DEVELOPMENT HEARING OFFICER

PR-2024-010464

VA-2024-00165 – SIDEWALK WAIVER
IDO -2022

ON THE LEVEL BUILDERS | DAVID CAMPBELL agent for KATE NOVINC requests the aforementioned action(s) for all or a portion of: LOT 9, BLOCK 10, GLENWOOD HILLS NORTH UNIT 1 zoned R-A, located 4901 Glenwood Hills Dr NE between NUBE BLANCA and MANITOBA DR NE containing approximately 0.278 acre(s). (F-23)

SITE PLAN
1"=10'-0"

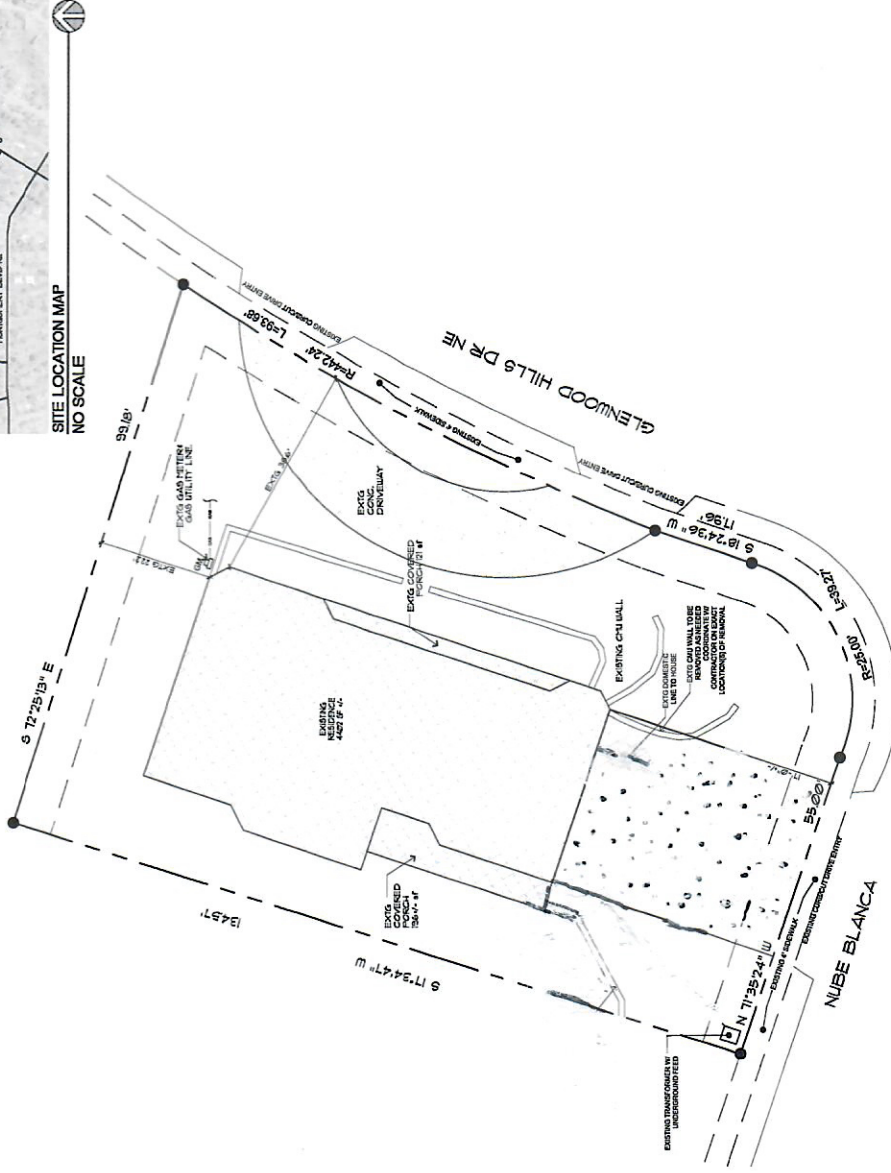
1. Code Enforcement has no objections based on existing lengthy driveway in front yard, and defers to Transportation regarding adequacy of length of driveway in side yard.

1. Unfortunately, Transportation cannot support this waiver. The purpose of the 20' setback is to avoid vehicles parking where they block the sidewalk and 17' does not provide enough space to avoid this.

- Per the analysis of Planning staff, the Applicant failed to adequately justify the Waiver per 6-6(P)(3) of the IDO. Additionally, Transportation staff in their memo note that they can't support the Waiver, noting that the purpose of the 20-foot setback is to avoid vehicles parking where they block the sidewalk, noting that 17-feet does not provide enough space to avoid this.
